**From:**  
**Sent:** 28 December 2024 13:23  
**To:** DC Admin; Joanna Rednall; Cllr Jo Lawson;  
**Subject:** planning application 2024/62/93007/W – 67a Crosland Hill Road

**Planning application 2024/62/93007/W – 67a Crosland Hill Road, Crosland Hill, Huddersfield, HD4 5NZ.**

DRAWING TITLE
PROPOSED ELEVATIONS

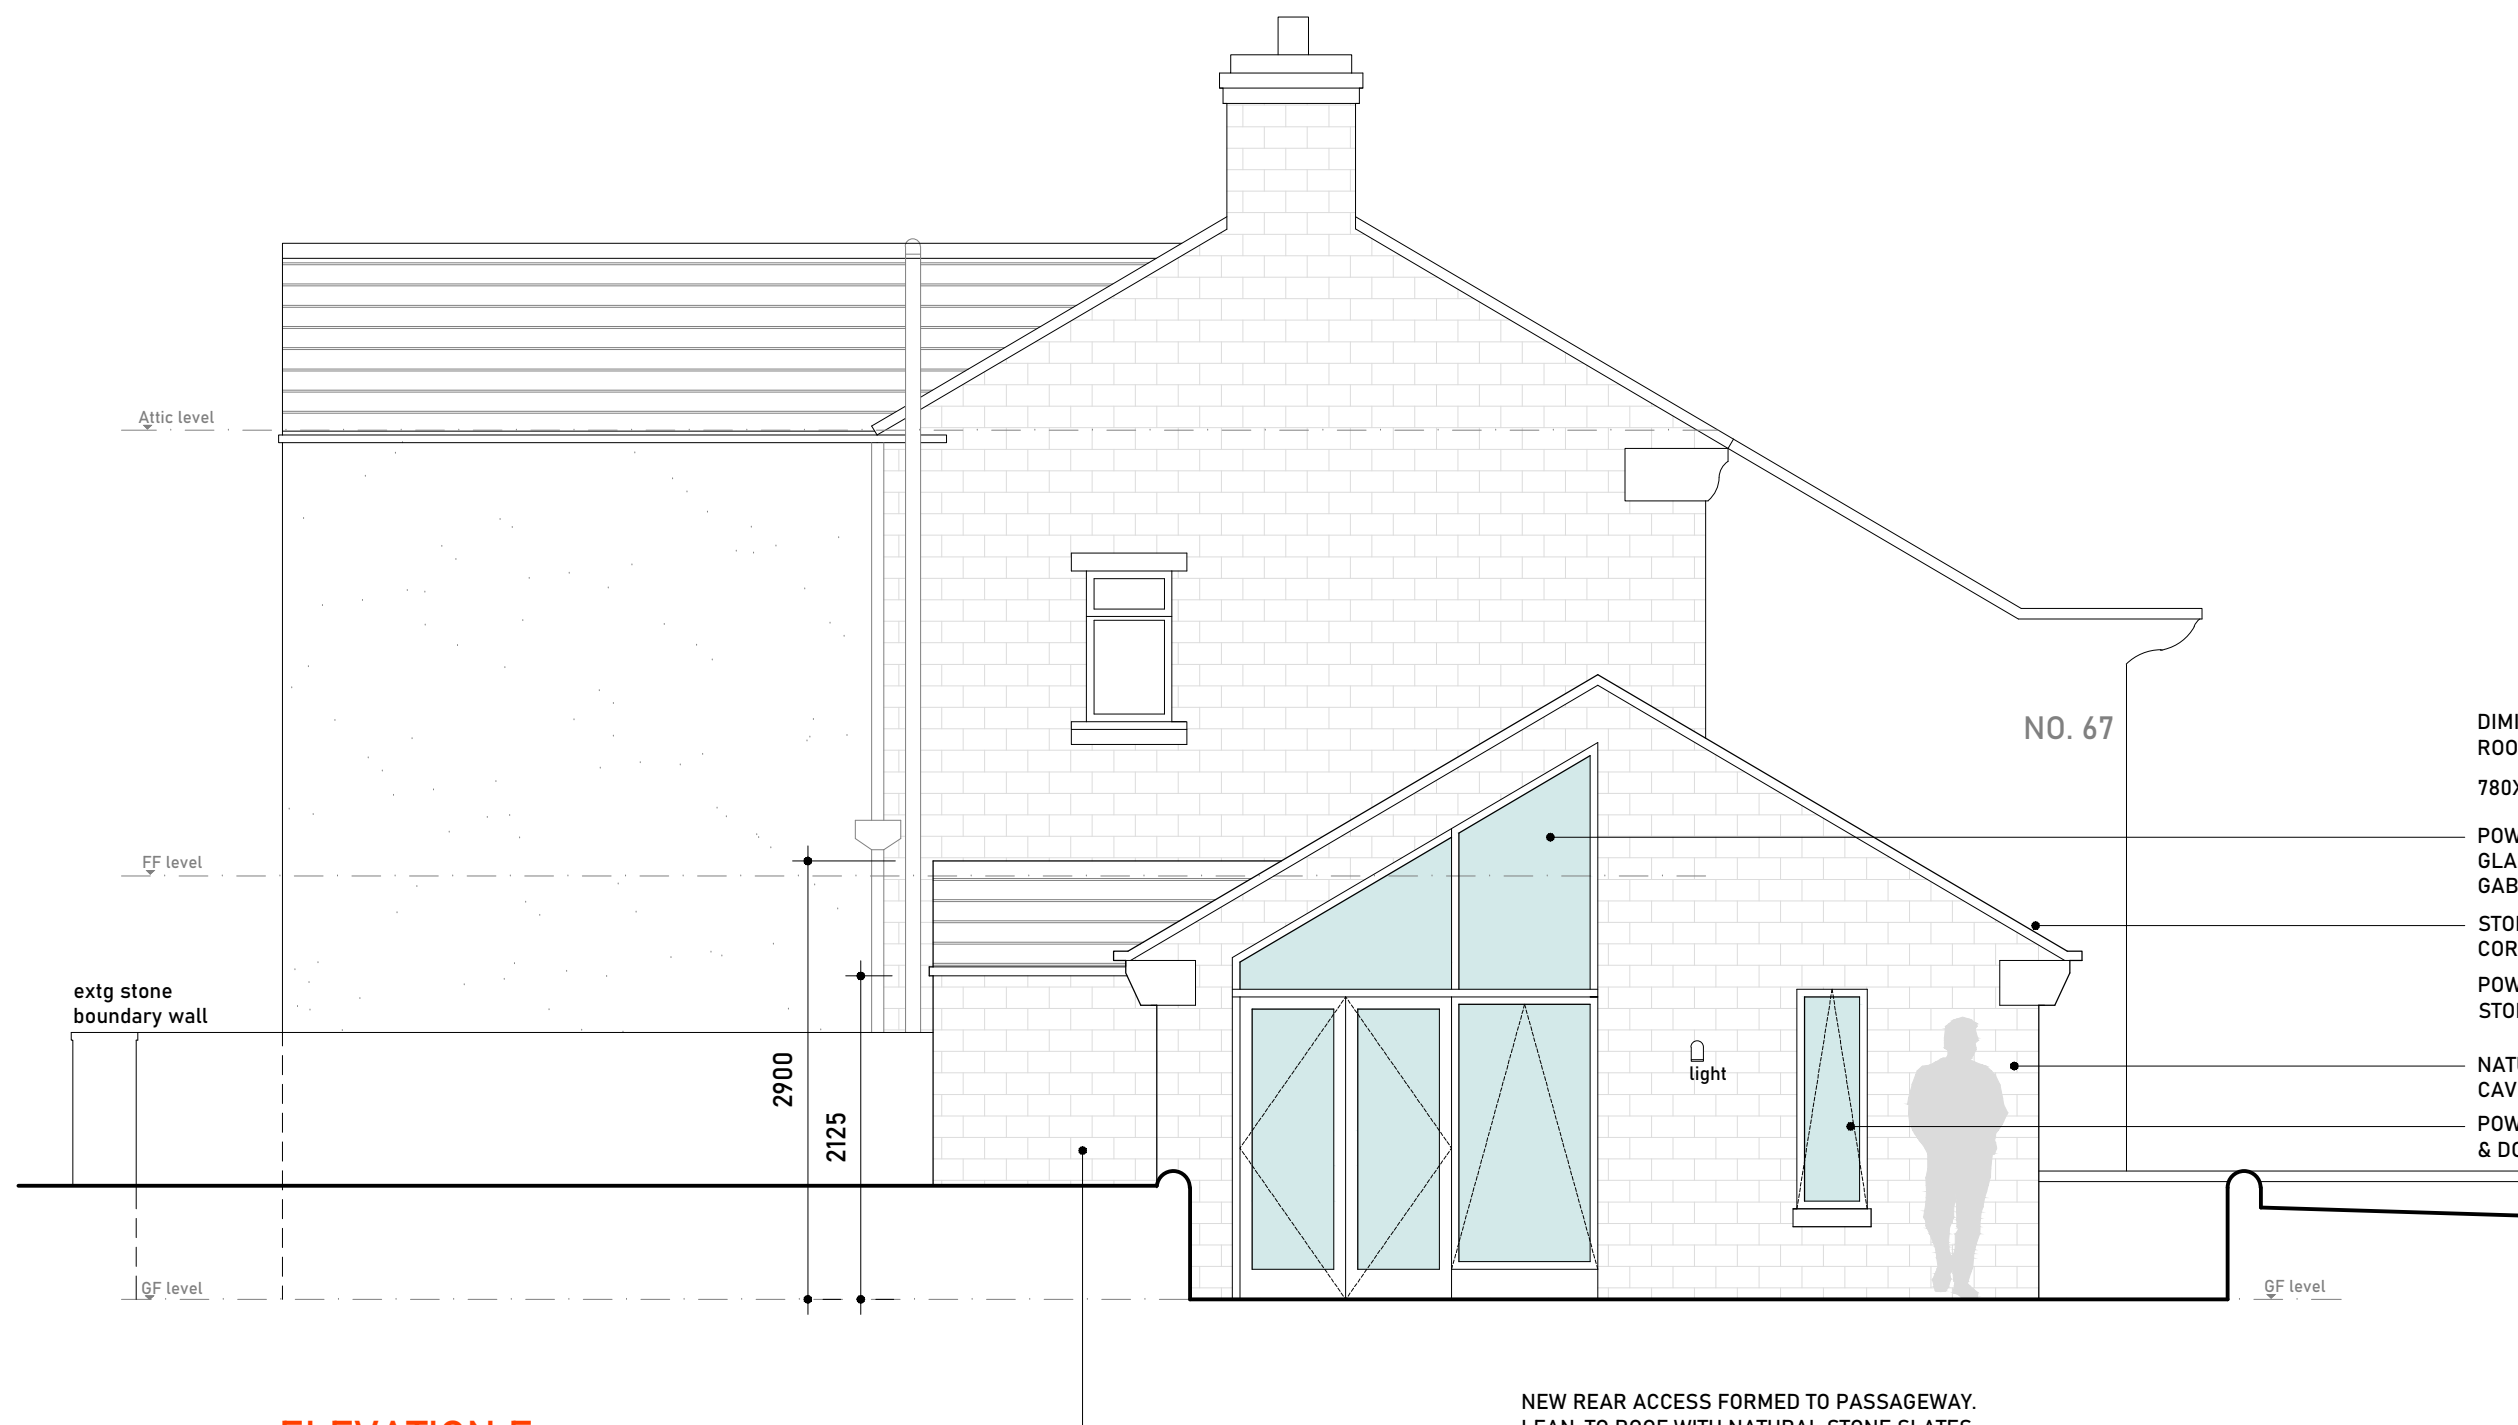
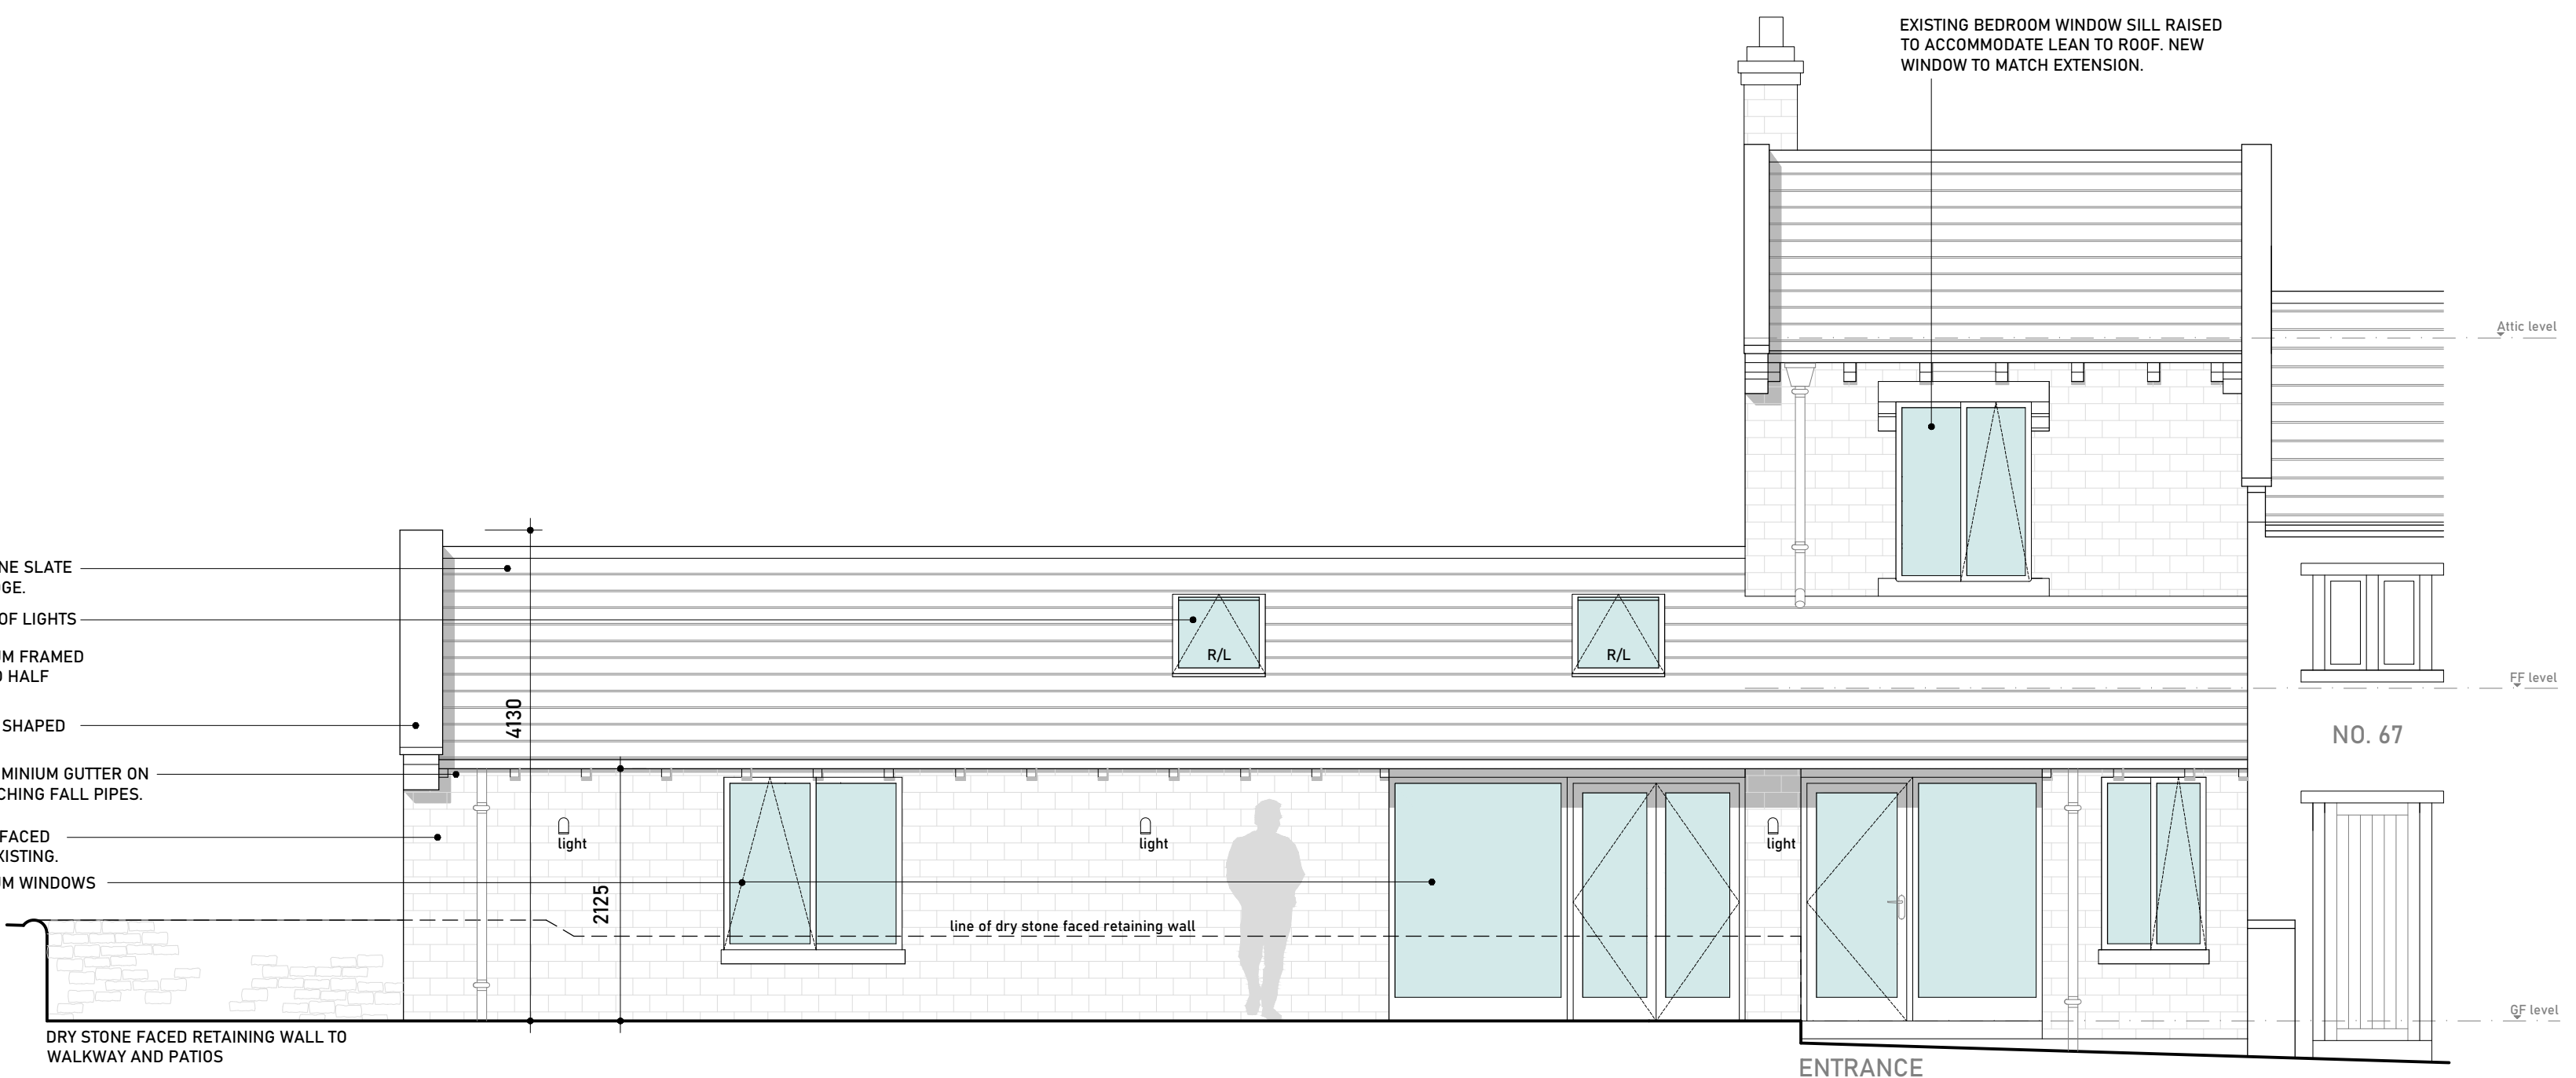
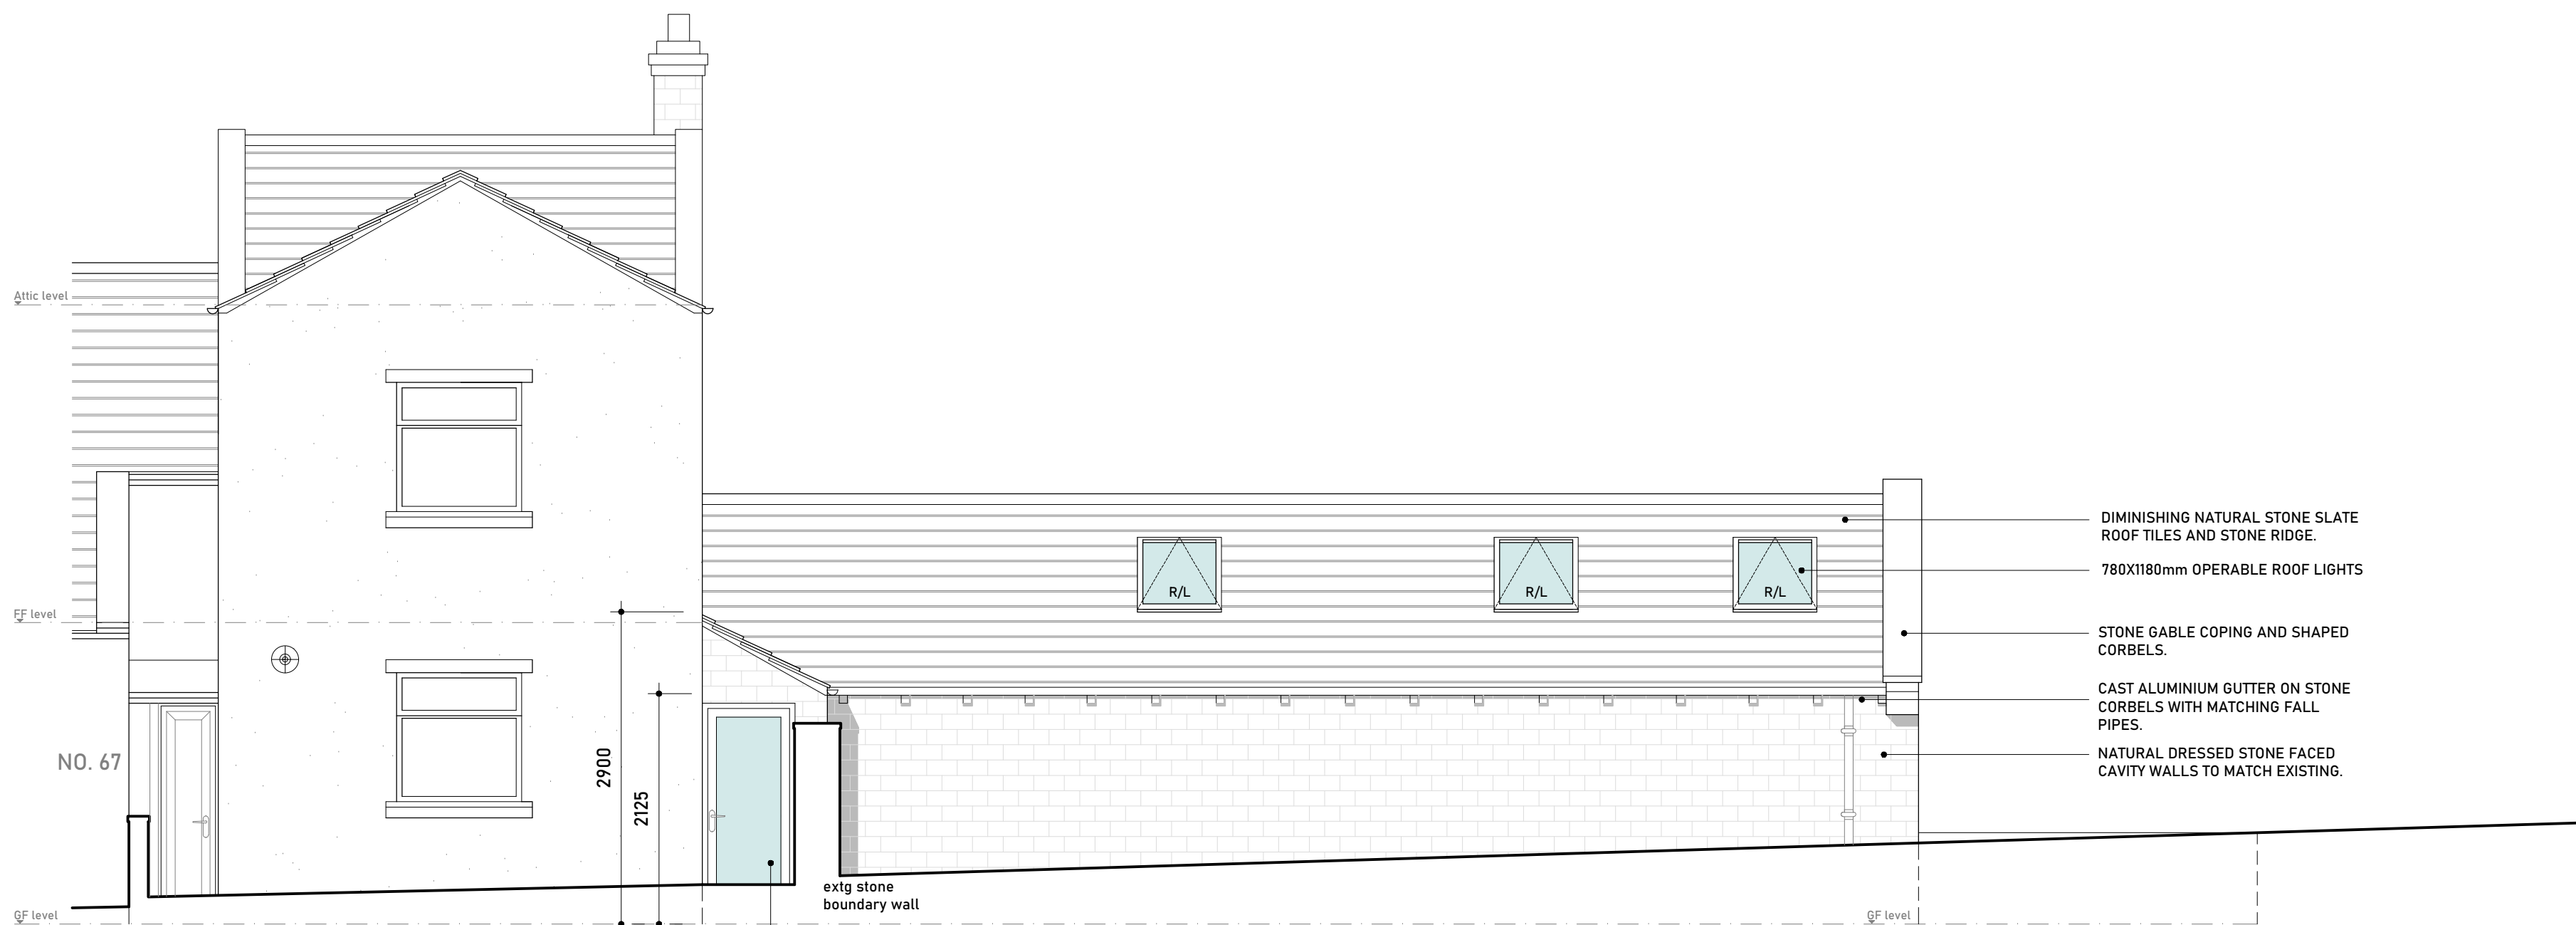
- WALLS - proposed natural stone – will this be a dressed York sandstone?
- ROOF – proposed is stone slate tiles – are these a local York stone or are they black welsh slate tiles?
- Windows – proposed powder coated aluminium surrounding buildings are not in keeping with surrounding grade II listed buildings on our shared lane.
- Vehicle access & hard-standing – Stone sets is a vague answer. This should also **not** include the shared access drive.

- It states “single storey extension with pitched roof and roof lights to existing dwelling” – this description is incorrect as the pitched roof lights are not shown on the drawing of the existing building.

- NPPF, Contents 16 – paragraph 203, section F – *“the desirability of a new development should make a contribution to the local character and distinctiveness”* We note on the plans they propose to use inappropriate modern LARGE powder coated aluminium windows, this will not be in keeping with the surrounding properties.
